RE: New Suncadia Boundary Line Adjustment BL-17-00005

TO: All Staff
FROM: Justin Turnbull, County Surveyor 
DATE: May 30, 2017
SUBJECT: County Survey Review of Boundary Line Adjustment BLA-17-00005

Suggested changes – not required

DWN BY DLP	DATE 2/2014	JOB NO. 131201
CHKD BY GW	SCALE 1" = 100'	SHEET 1 OF 3

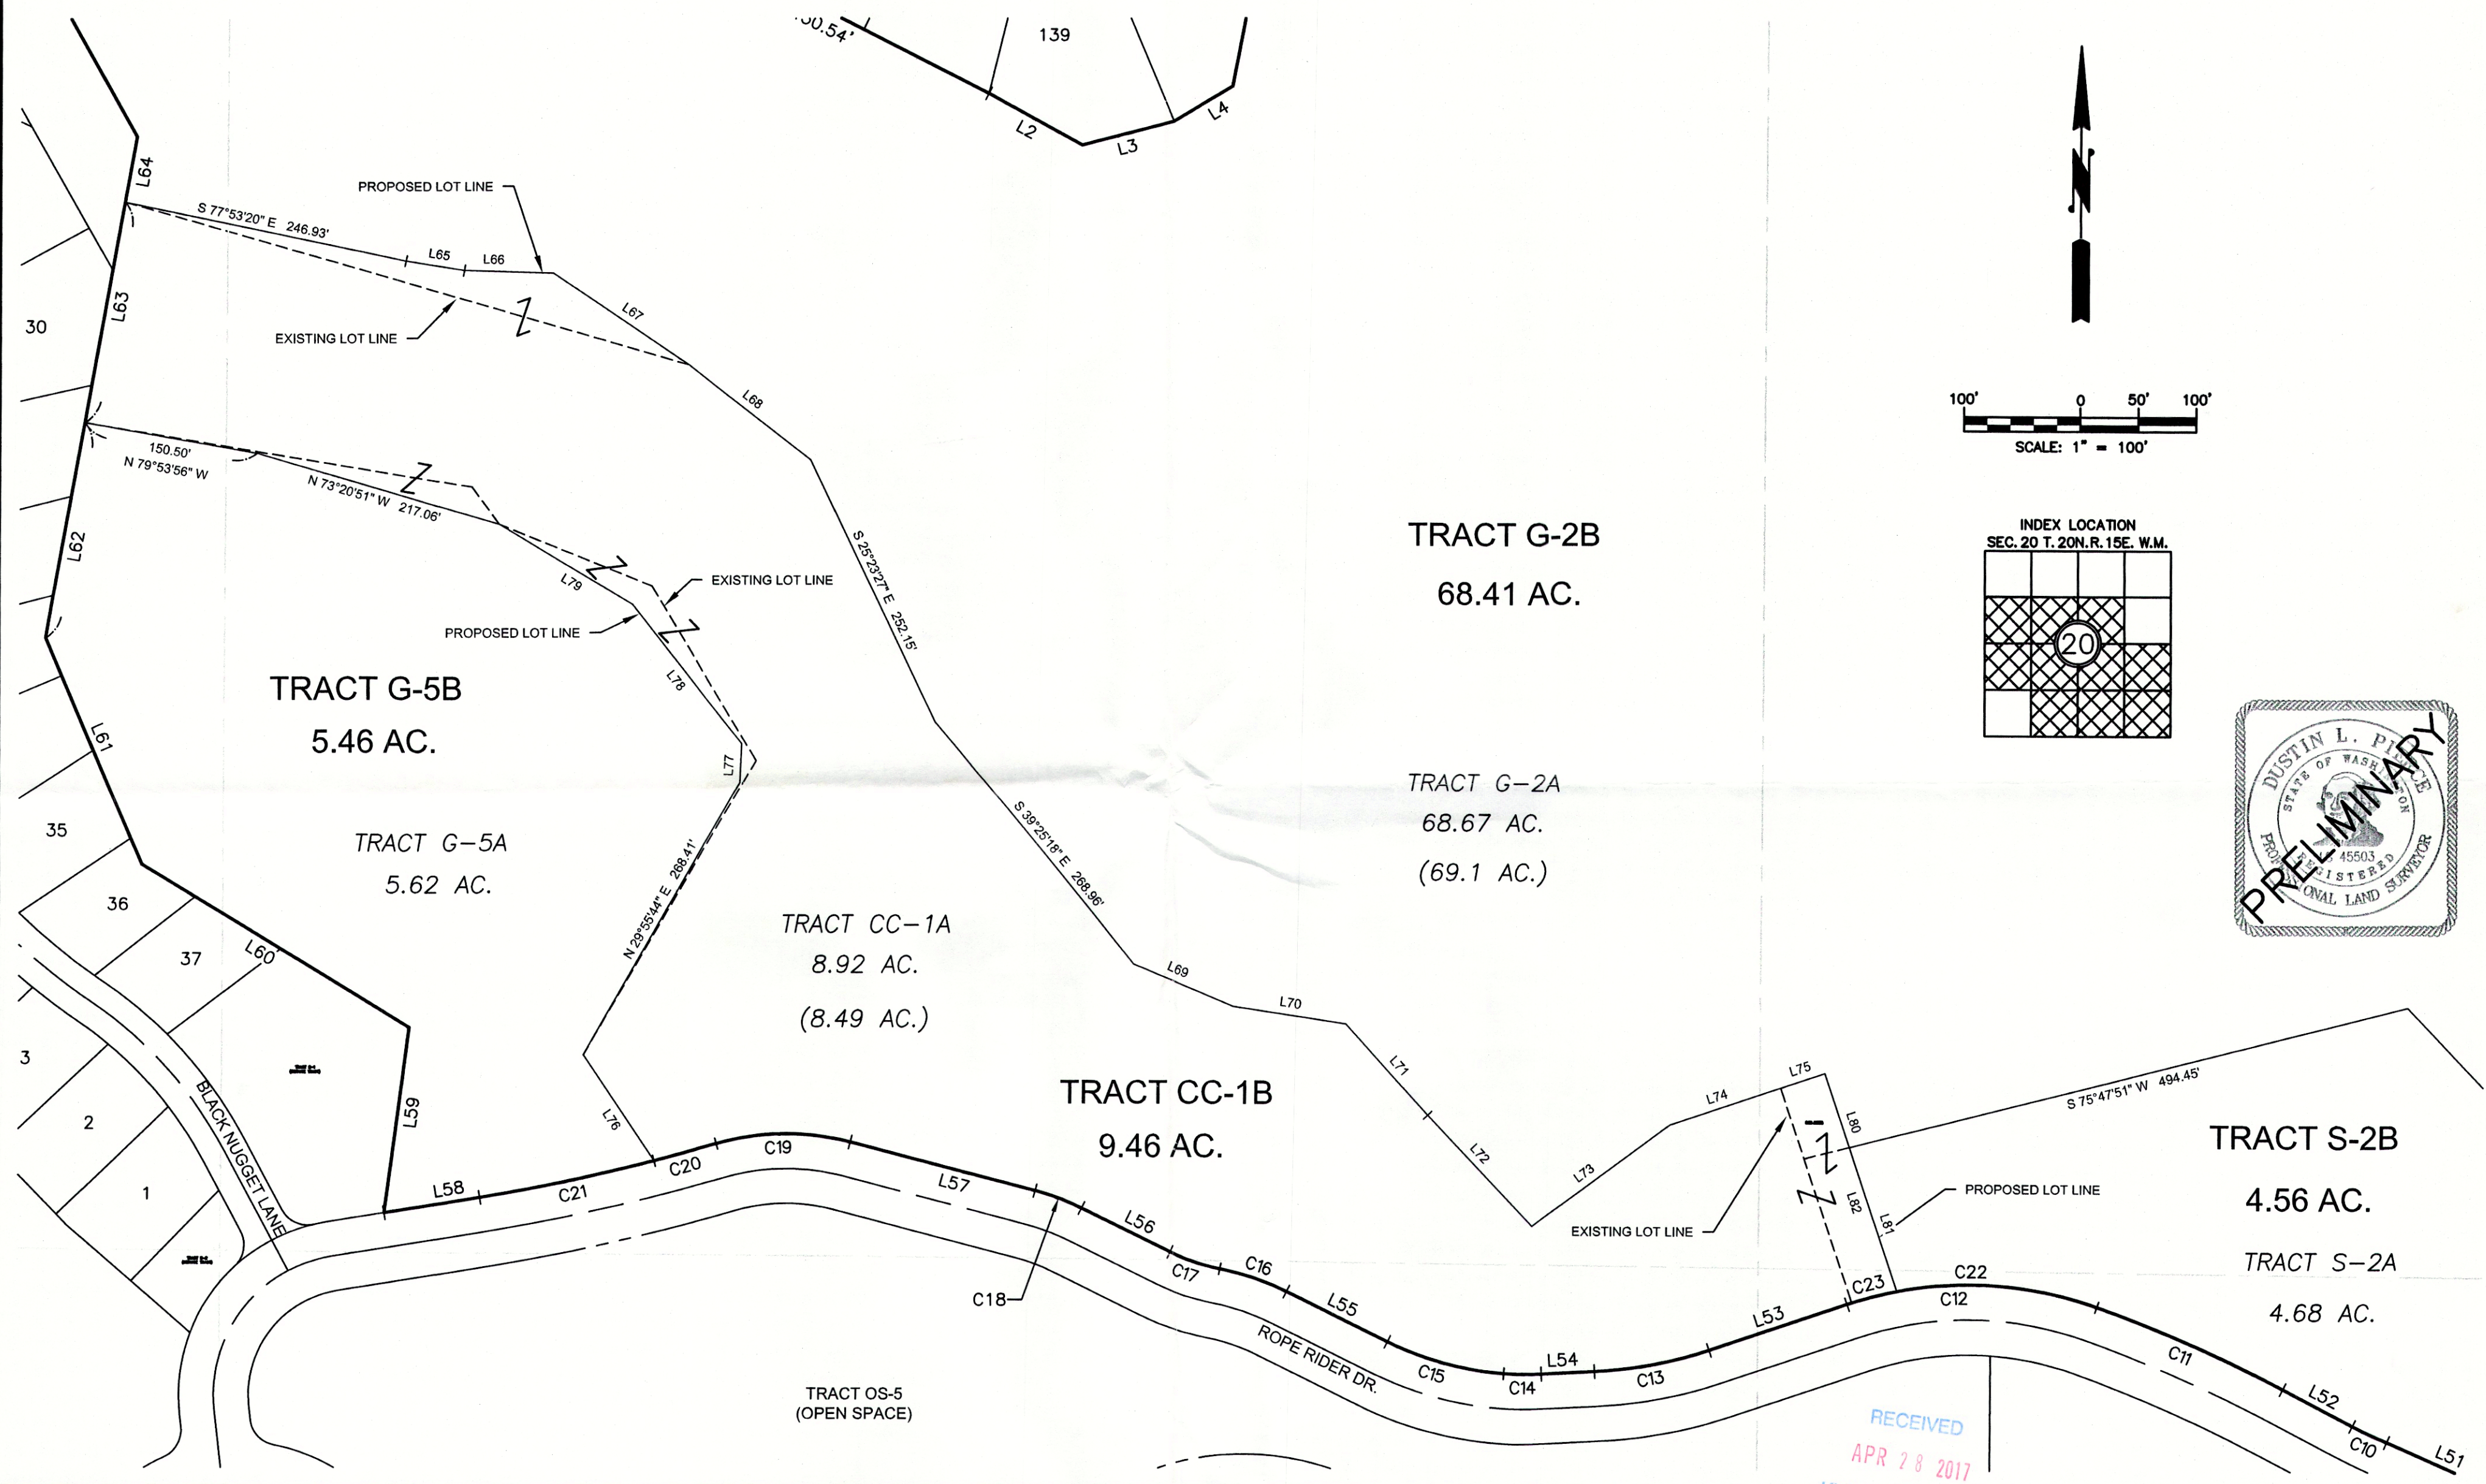
2. Sheet 1 shows some trimmed text at the top of the page, and text less than 0.08" in height near the lower left corner.
3. Roadways should be shown with name, width, ownership, Easement or R/W and surfacing (EX: Brown Rd – 60' Wide County R/W – Paved)

4. I believe the date on sheet 1 to be incorrect.
5. Basis of Bearing should be noted or stated.
6. Survey procedures statement should be shown.
7. Purpose of survey statement should be shown.

DWN BY	DATE	JOB NO.
DLP	2/2017	131201
CHKD BY	SCALE	SHEET
GW	1" = 200'	2 OF 3

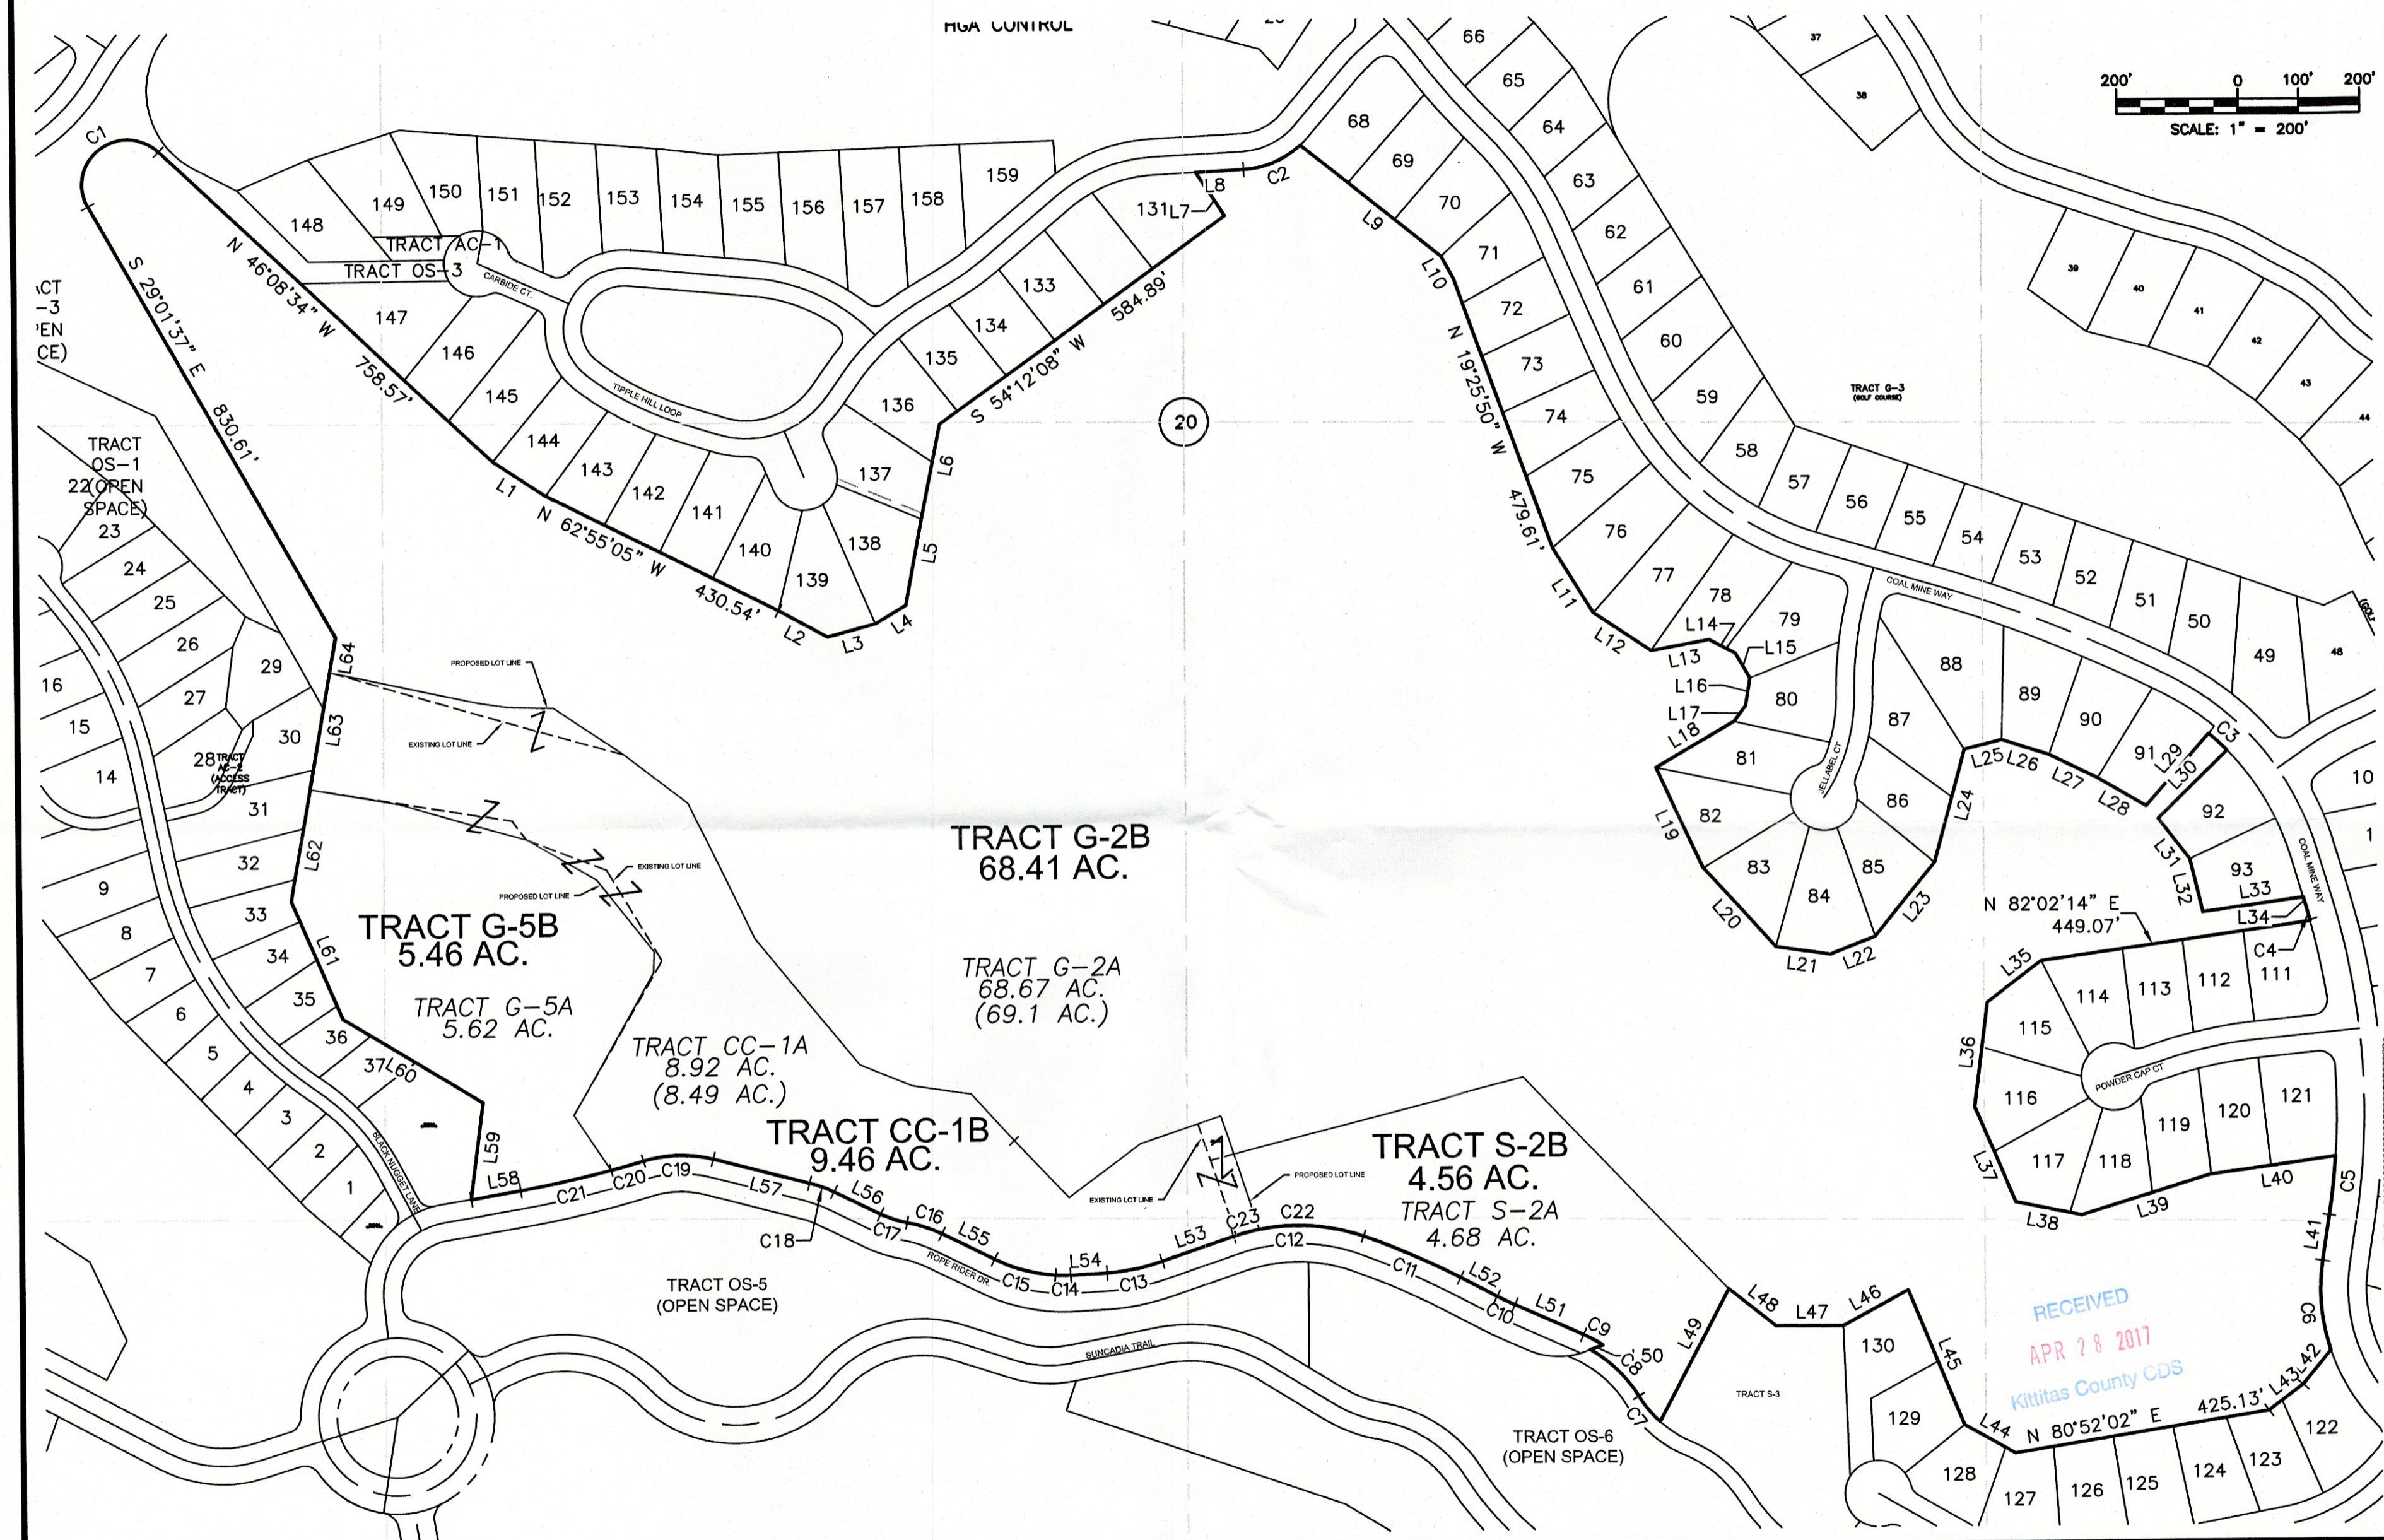
8. Controlling corners or monumentation should be shown or noted.
9. Sheet 2 shows multiple instances in road names, ex lot line labels and tract labels that do not meet 0.08" minimum text size. Additionally, there is some text trimmed near the top and left side of the page.
